Recommendation Report for Planning Permission for Works or Extension to a Dwelling

REF NO: AW/305/20/HH

LOCATION: 19 Wychwood Close
Aldwick
PO21 4DW

PROPOSAL: Installation of side dormer. This application may affect the setting of the Craigwell House Conservation Area.

Title
Plans as Proposed

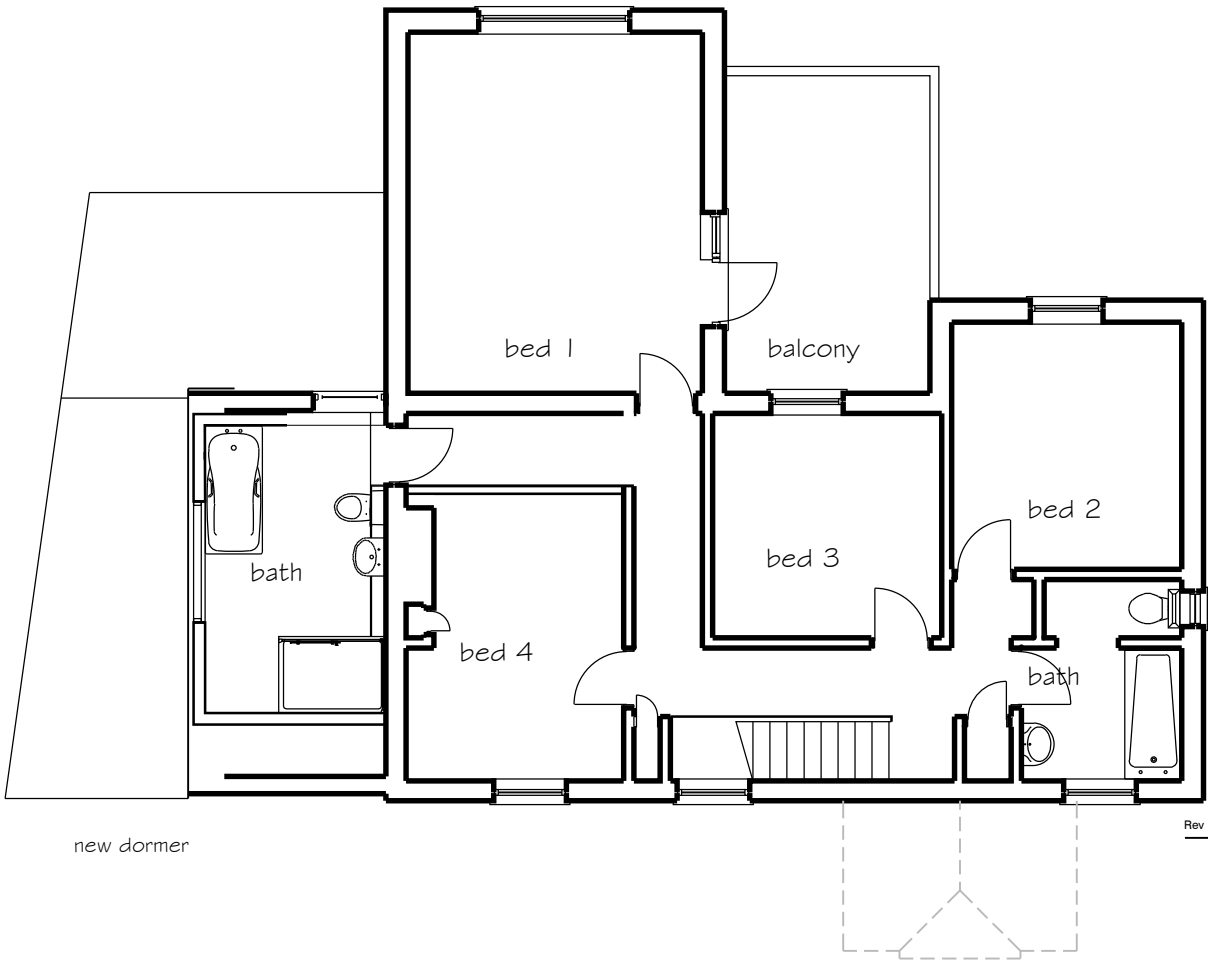
There will be 1 window to the dormer which faces north east. Due to the siting this could have views into the side elevation of the No.17 which features one window at 1st floor. As the dormer serves a bathroom, it will be conditioned that the window remains obscured glazed to ensure overlooking is mitigated.

- 3 The window serving the dormer to the north east elevation shall at all time be glazaed with obscured glass and only openable at a high level, at least 1.7m above finished floor level.

Title
Elevations as Proposed

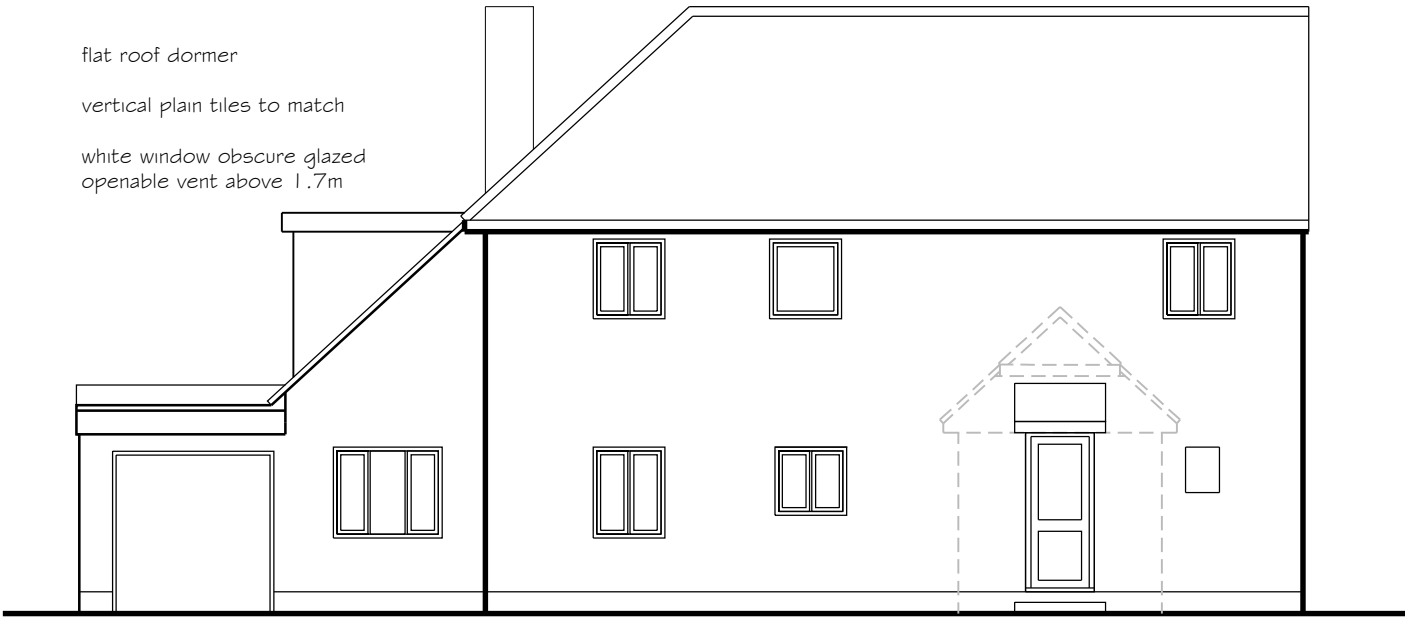
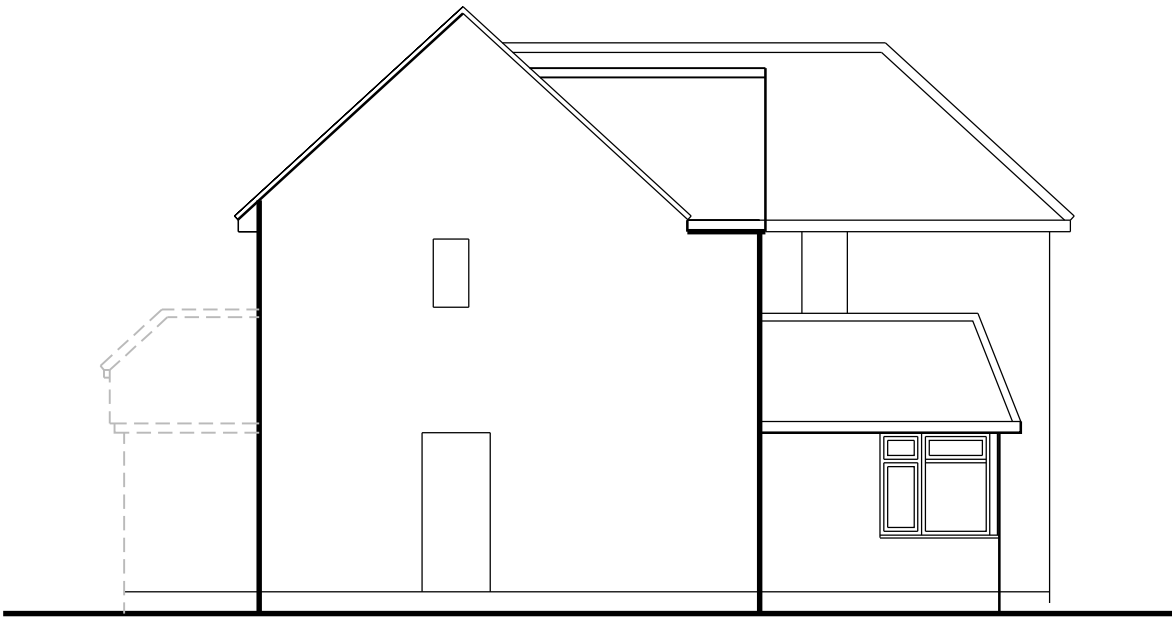
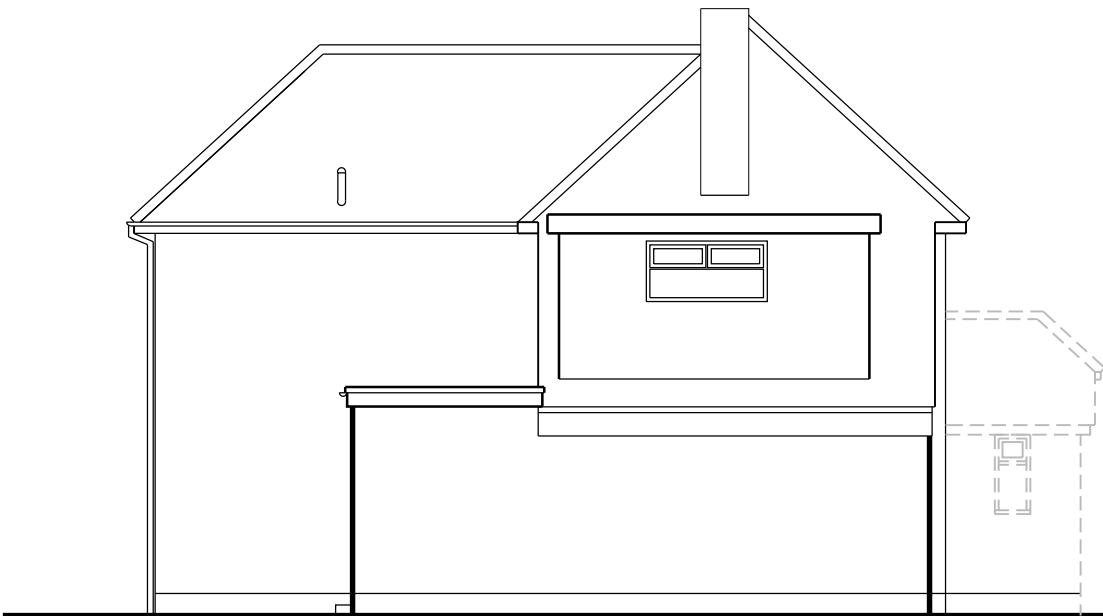
The surrounding properties are mixed in appearance and the dormer is not considered to appear unduly dominant, with the dormer set back around 0.85m from the front elevation.

The dormer will be tiled to match the host dwelling and will have a flat roof meeting with the eaves of the dwelling and appears well integrated.

The dormer will be located to the north eastern side of the dwelling. This will have a height of around 2m and a depth of 2.3m.
